MORGAN AND MORECAMBE OFFSHORE WIND FARMS: TRANSMISSION ASSETS

Annex 3.2.3 to Response to RR - Environment Agency (RR-677)

Document Reference: S_PD_3.2.3

11 April 2025
F01

Figure 1.2: Watercourse and waterbodies scoped in and survey numbers – Section 1

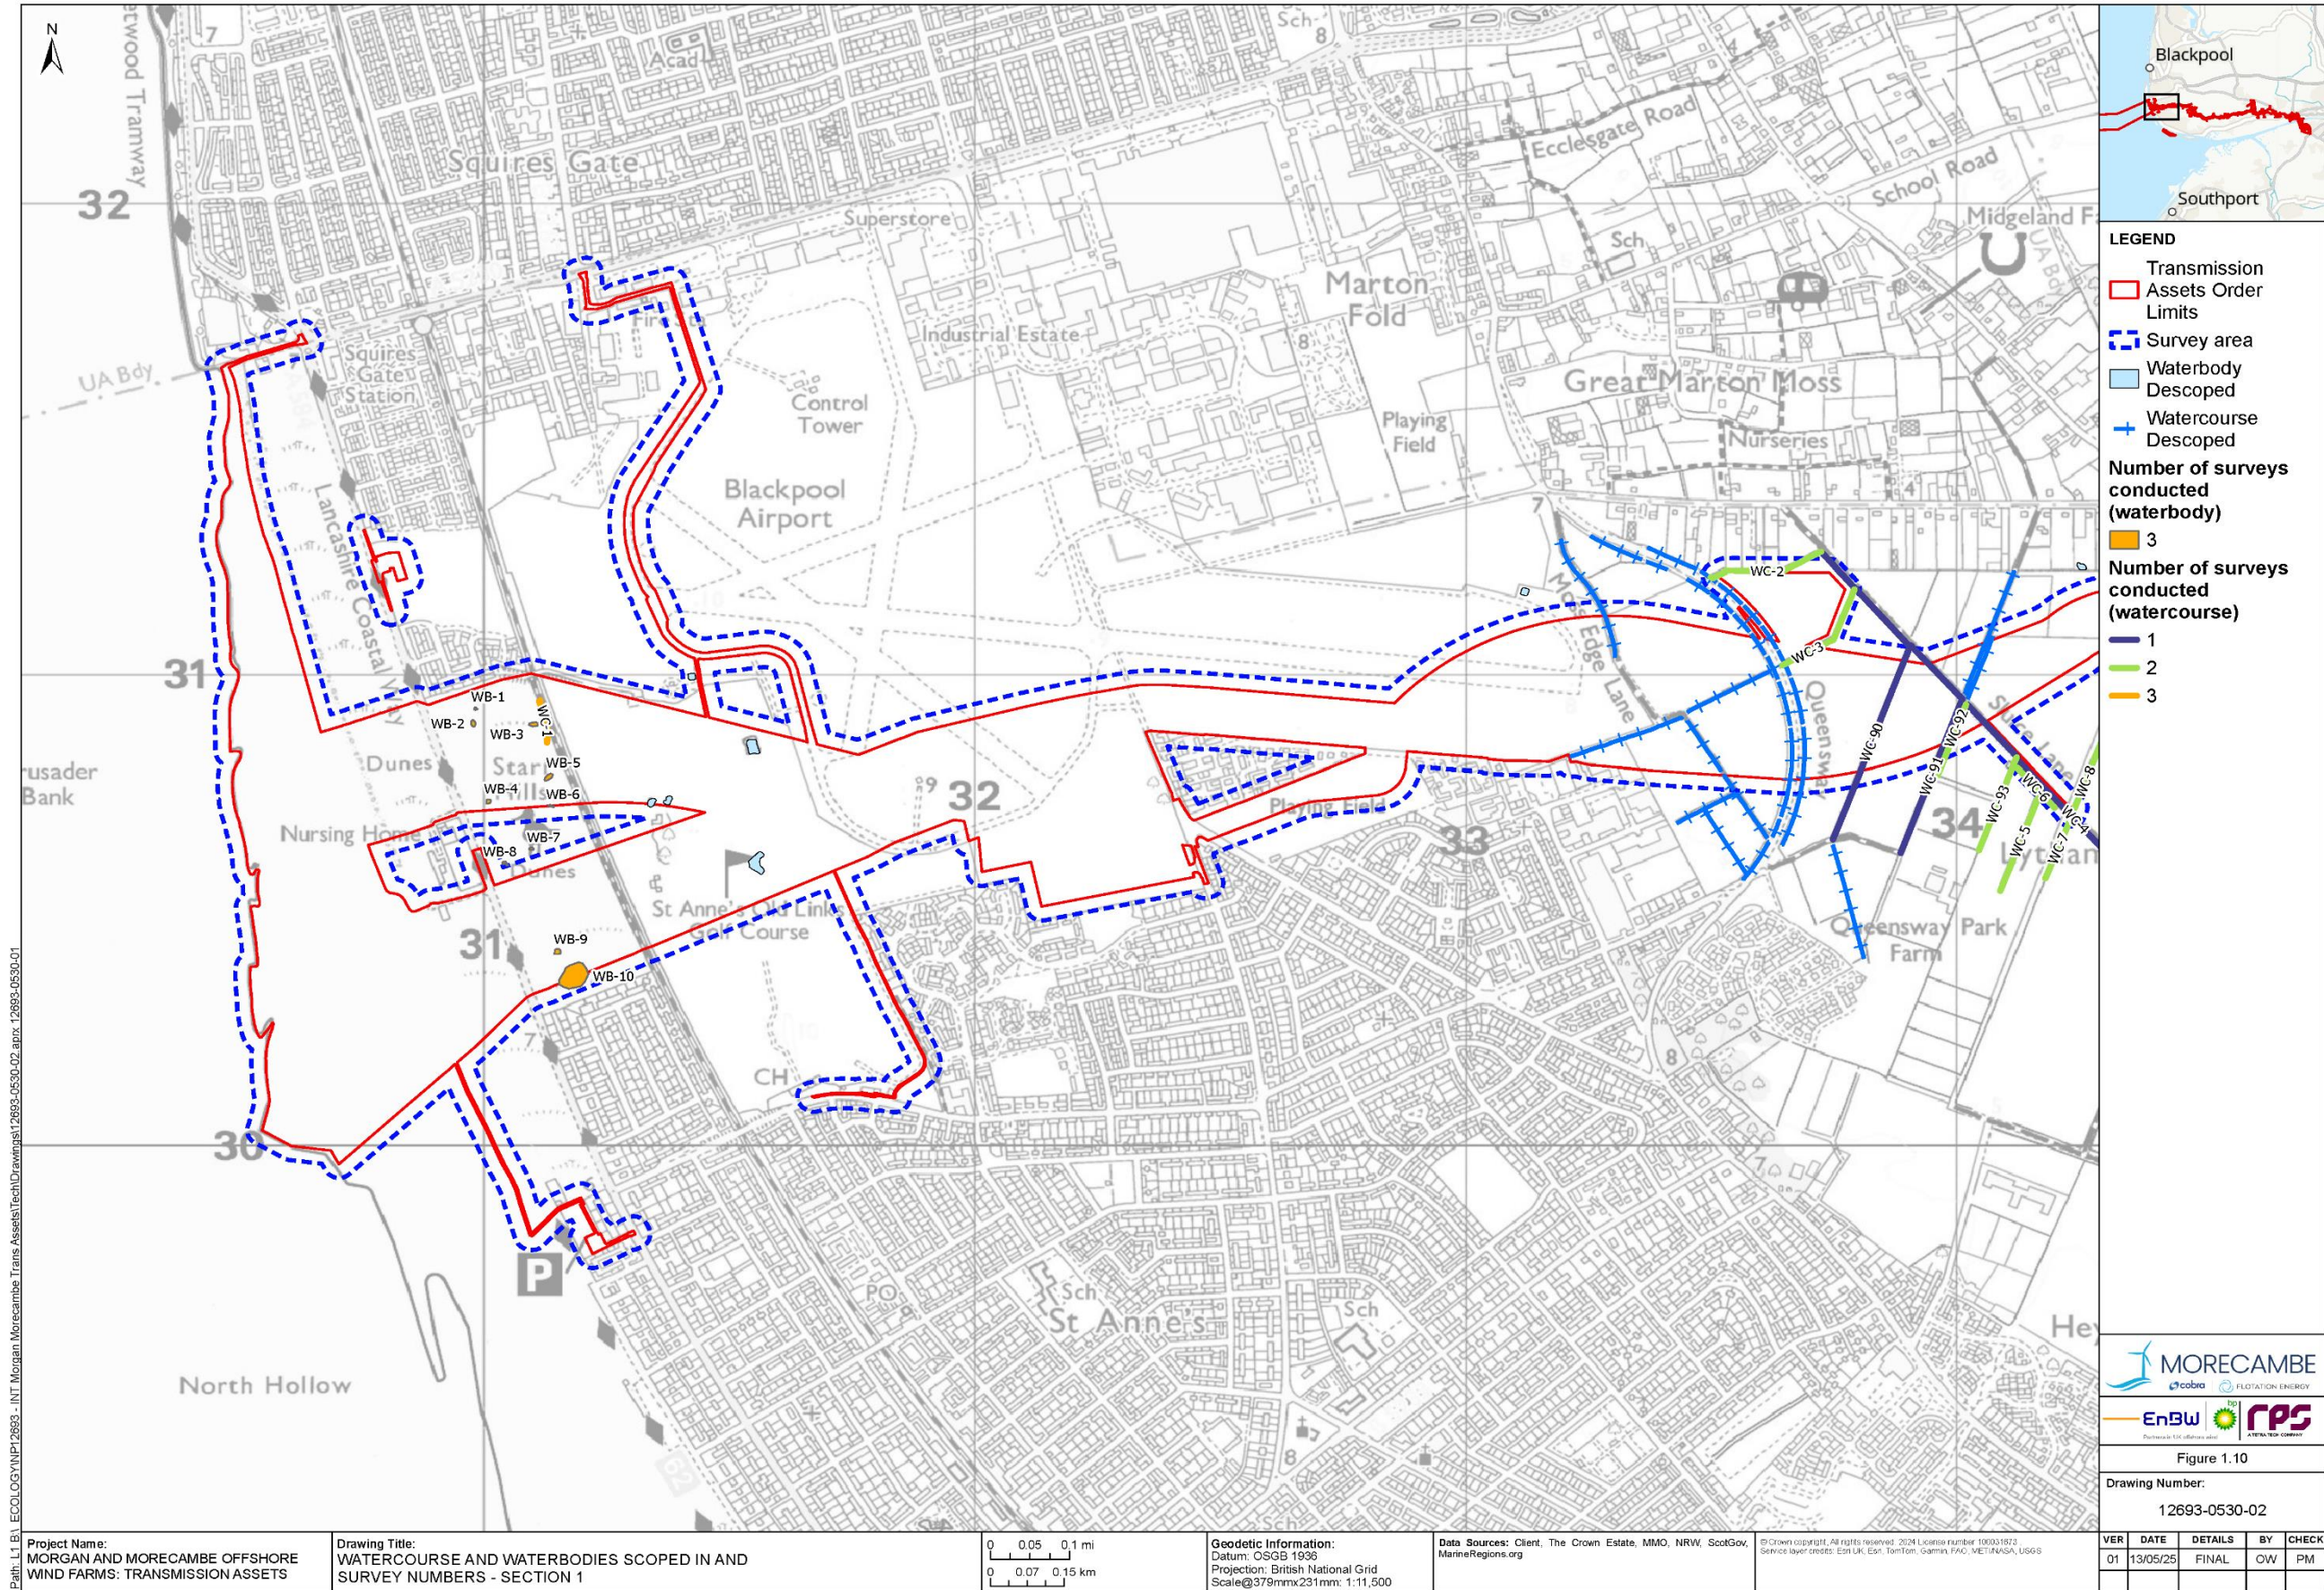
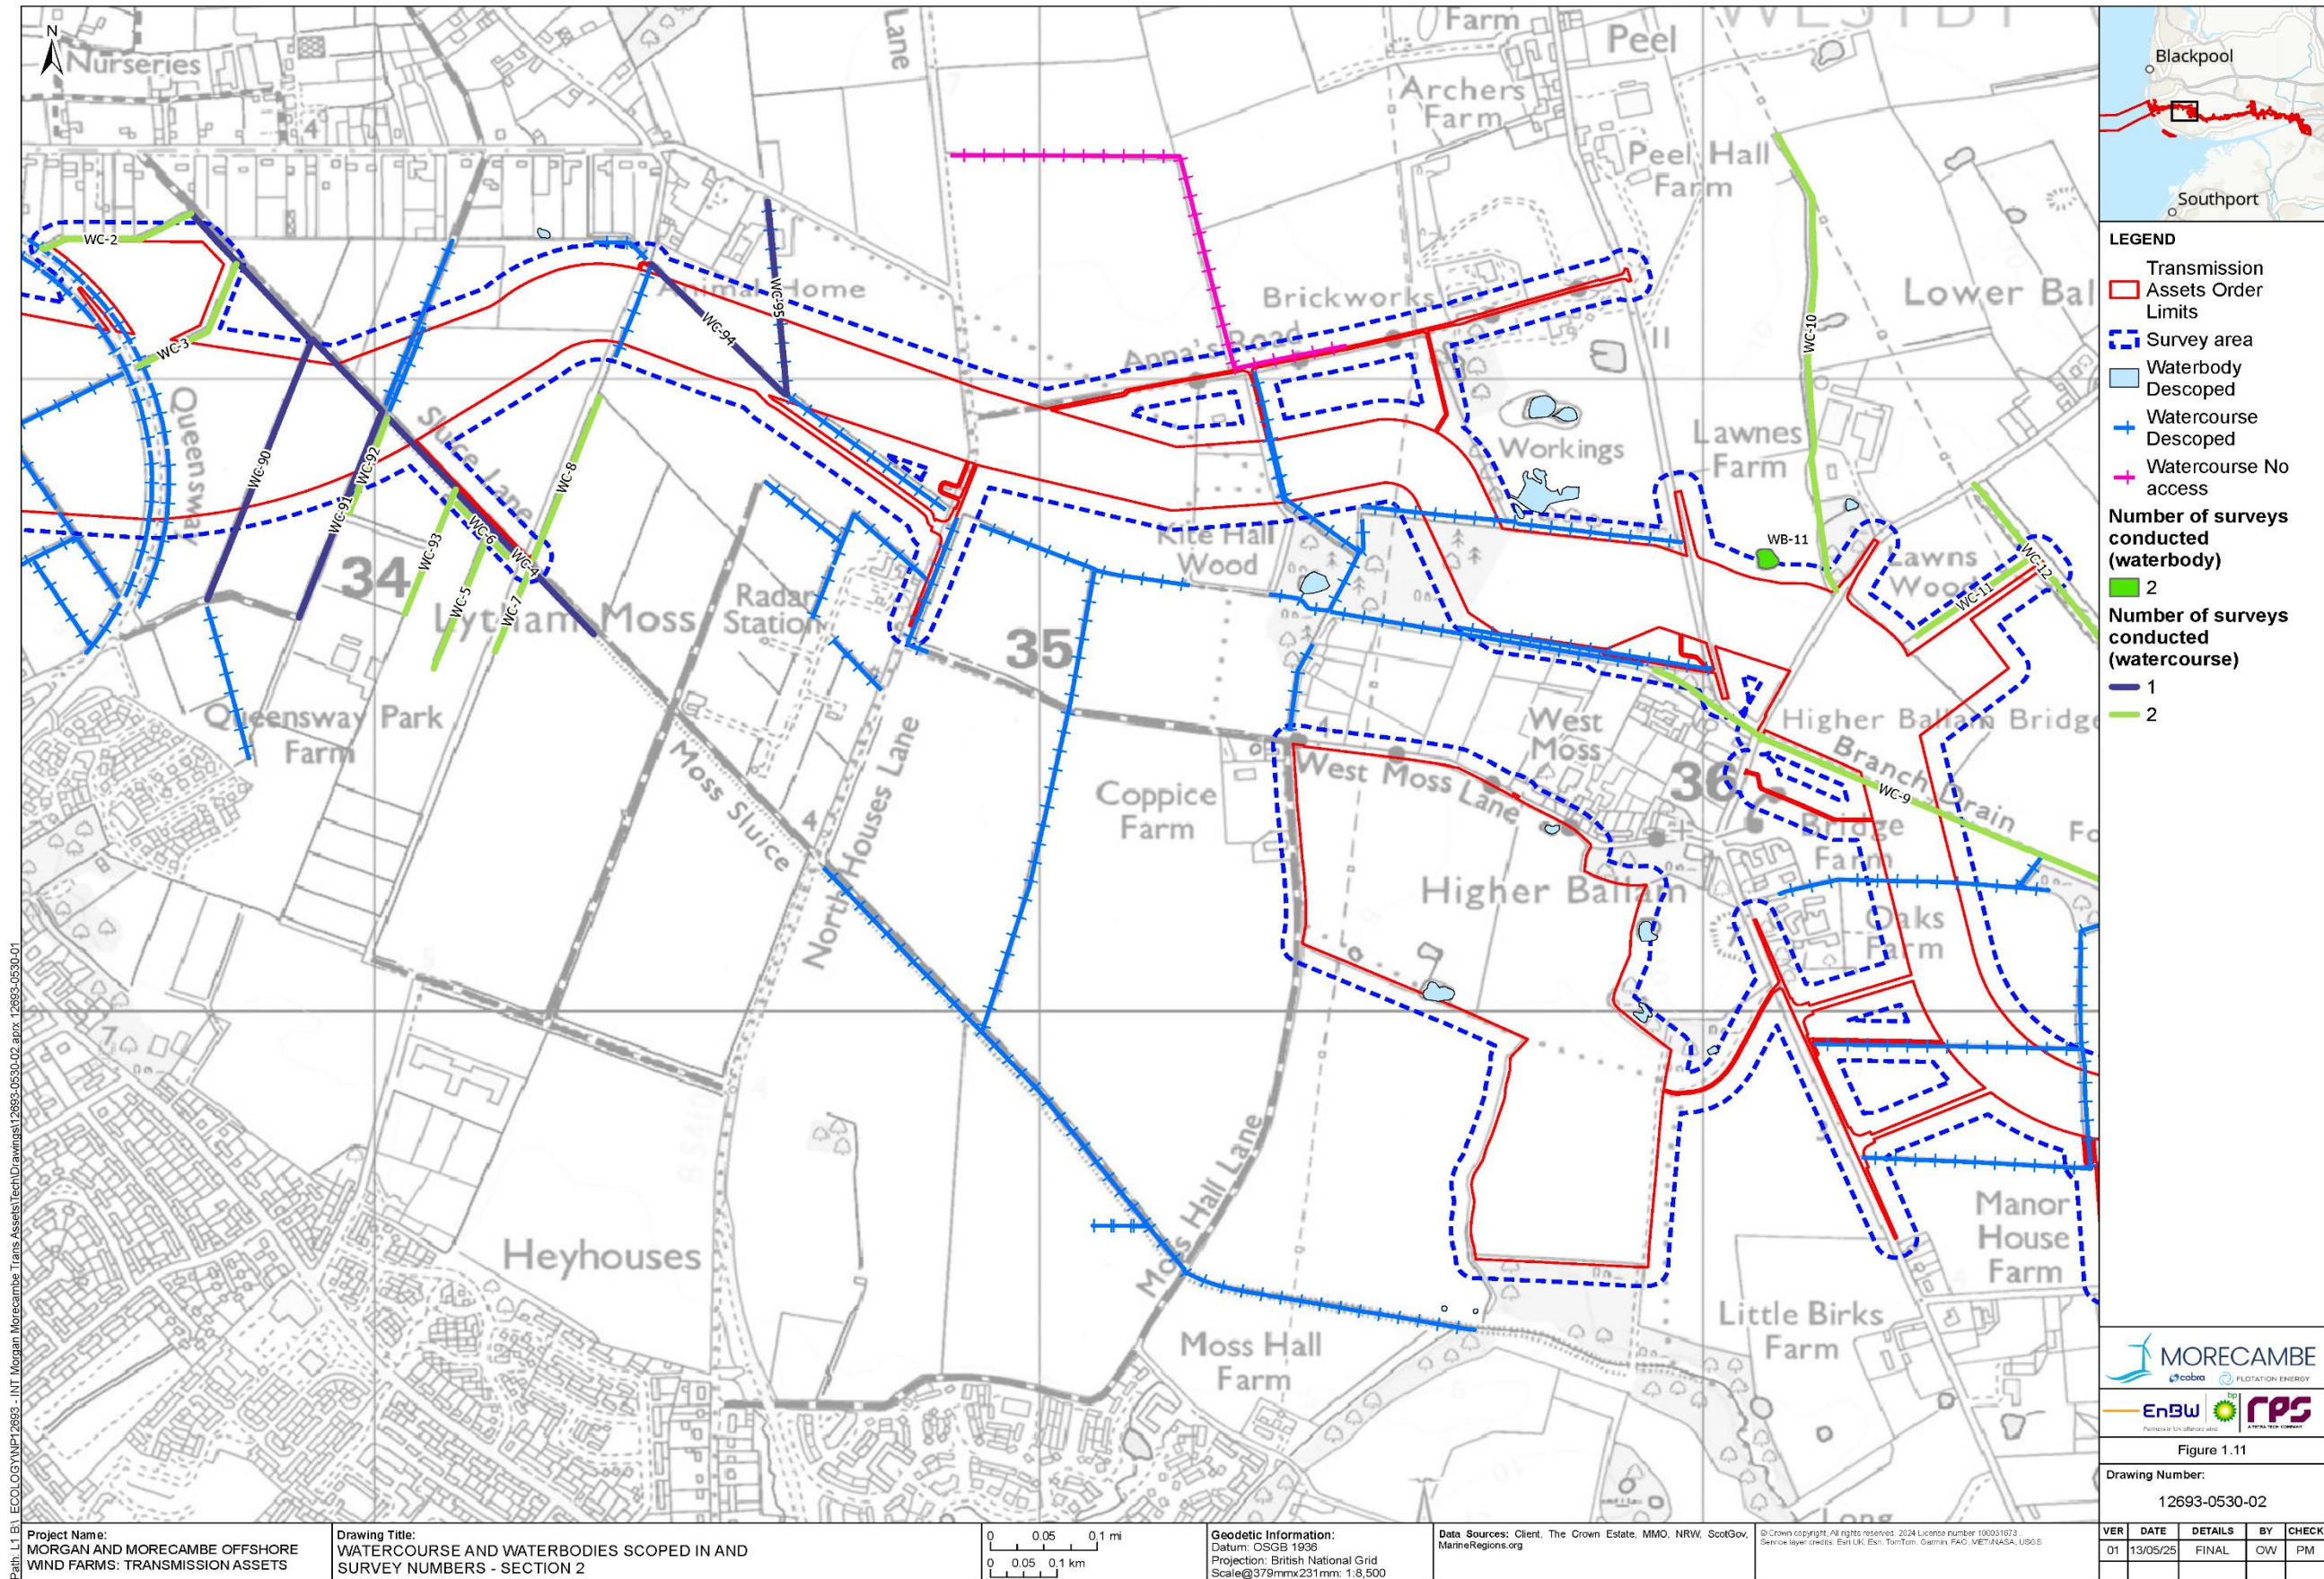
RR-0677 0677.12 (Appen. 1 APP-083)	<p>Water vole survey technical report</p> <p>Section 1.2.4.16 and 1.2.4.17: Water vole surveys have been undertaken following periods of weather extremes. The surveys in June 2023 were undertaken following an extended period of hot dry weather. The survey in April 2024 was undertaken following a period of heavy rainfall.</p> <p>Possible under-recording. Evidence of water vole are less likely to be recorded following dry weather, and evidence may be washed away during heavy rainfall.</p> <p>The report confirms that 'late season' water vole surveys were ongoing at the time of DCO submission. Once complete this report should be updated to reflect the results and submitted for review.</p>	<p>A campaign of water vole surveys was undertaken between April 2023 and July 2024 on land parcels with habitat that could potentially support water vole and where access was agreed. The surveys were undertaken in accordance with the methodology agreed with the Environment Agency (as part of the EWG) and the results were reported in Volume 3, Annex 3.9: Water Vole Survey Technical Report (APP-083). The water vole survey methodology requires two visits within the breeding season (i.e. early season (between mid-April to June) and late season (between July and September)).</p> <p>The Applicants responded to comments regarding the weather conditions during the June 2023 water vole surveys in Table 3.5 of Volume 3, Chapter 3: Onshore Ecology (APP-075) and subsequent surveys were undertaken in 2024 where access was permitted. A summary of the surveys (as set in Table 3.15 of APP-075) found there was little confirmed evidence of water vole and (together with the infrequent but widespread evidence of mink) considered water vole to be of local importance within the survey area. However, a precautionary approach was adopted for the assessment which assumed that water voles to be present where potentially suitable habitat had been recorded.</p> <p>The Applicants confirm that water vole surveys were undertaken in late August, September 2024 and the first week of October 2024 (as weather conditions allowed the</p>

Reference	Relevant Representation Comment	Applicants' response
		<p>surveys to be recorded as a 'late season' survey). These surveys formed part of the late season surveys that were being completed in accordance with the seasonal survey restrictions and the methodology of the previous water vole surveys. Given the timing of the surveys, the results were not included in the DCO application.</p> <p>The Applicants confirm that Volume 3, Annex 3.9: Water Vole Survey Technical Report (APP-083) will be updated to show the location of these surveys and will be submitted at Deadline 1 of the DCO Examination. The Applicants confirm that no new evidence of water voles was recorded during the late August to early October surveys and therefore, the characterisation of the baseline and the conclusion of the assessment as reported in Volume 3, Chapter 3: Onshore Ecology (APP-075) remain unchanged.</p> <p>Preconstruction surveys for European Protected Species (including water vole) will be undertaken (as secured in Requirement 13 of Schedules 2A & 2B the draft DCO (AS-004)). As set out in the Outline Ecological Management Plan (OEMP) (APP-212) the water vole surveys will be undertaken along all ditches of potential value to water voles that would be affected during construction.</p>
